**Our ref:** AN/2025/137356/01-L01  
**Your ref:** H14-1219-25  
**Date:** 09 January 2026

**Change of use to 2 separate dwellings  
Sense 38, Church Street**

**Environment Agency response**

Client: MR. & MRS. P. FOX JANICE KENDRICK DESIGN SERVICES	Proposal: CHANGE OF USE TO TWO DWELLINGS AT 38 CHURCH STREET, PINCHBECK e-mail- jkds@talk21.com tel : 07711 007209	Scale @ A3 1 : 100 Dwg No. 25. 3674. 01	Title EXISTING GROUND FLOOR
---	--	--	------------------------------------

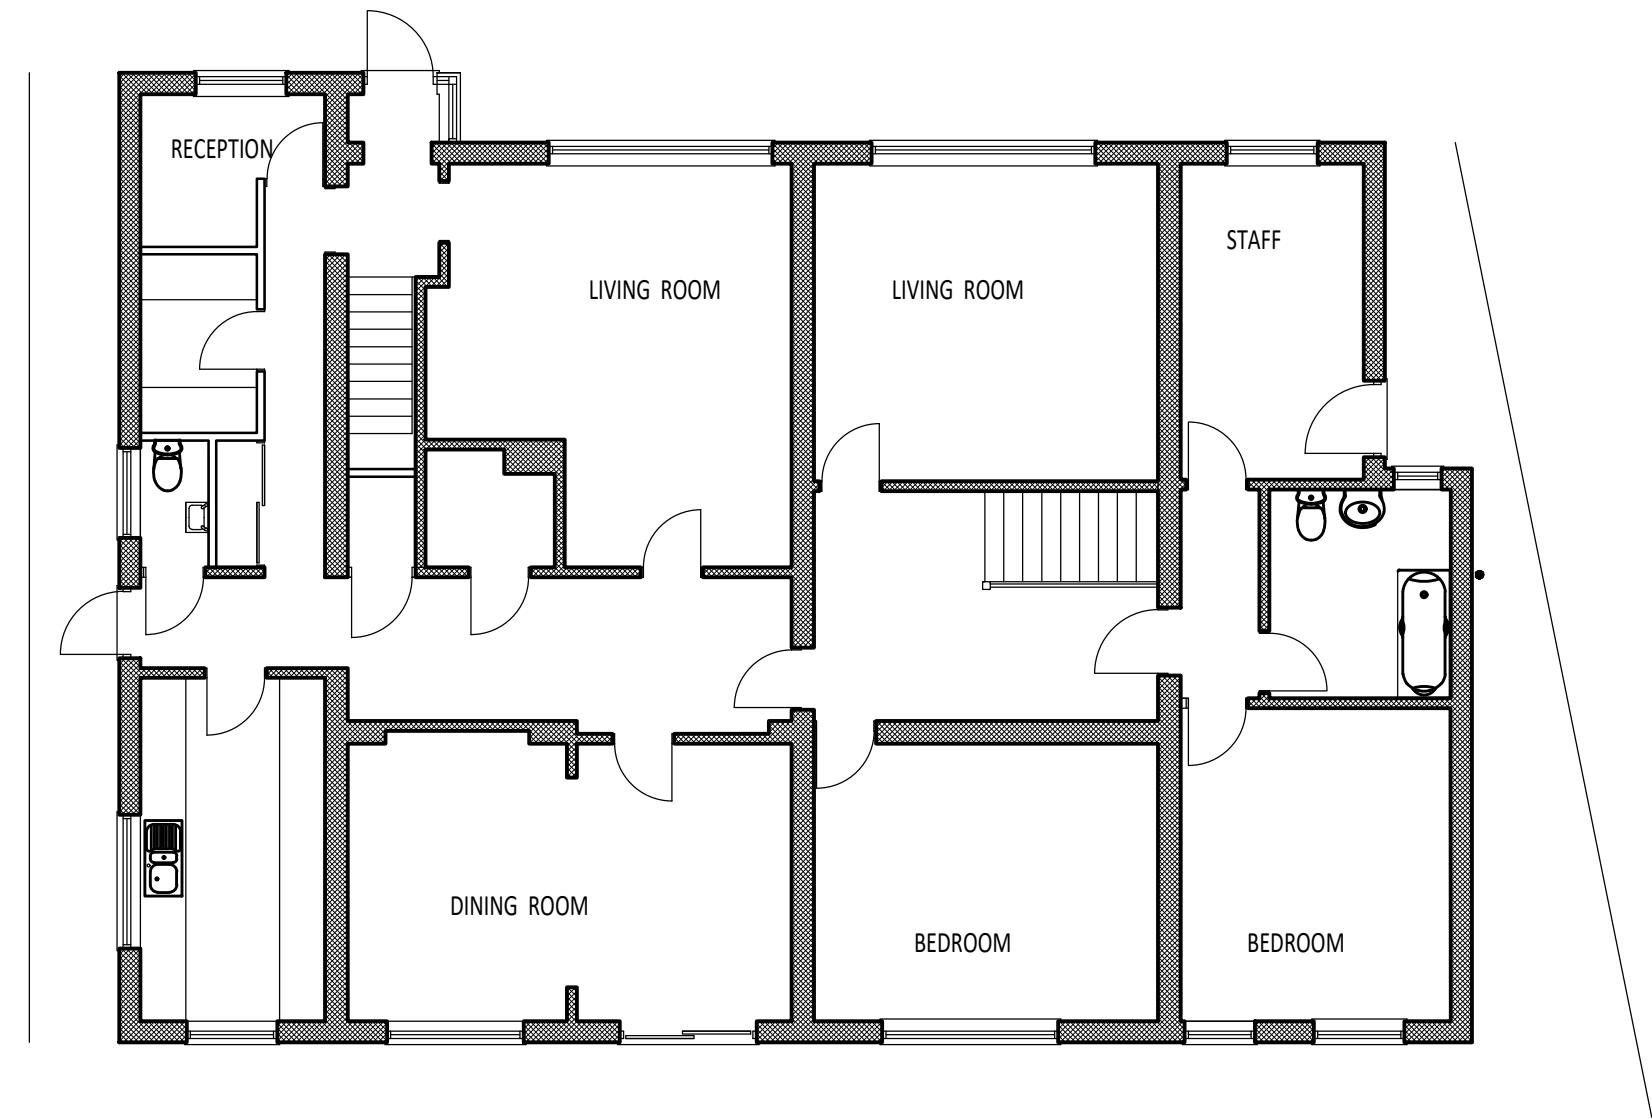
We support that the proposed floor plans show the removal of ground floor bedrooms and therefore we have **no objection** to this application. We recommend that flood resilience measures, as proposed in the submitted flood risk assessment, are fully implemented. Further guidance on flood resistance and resilience measures can be found in: CIRIA Code of Practice for property flood resilience [Code of practice for property flood resilience C790](#).
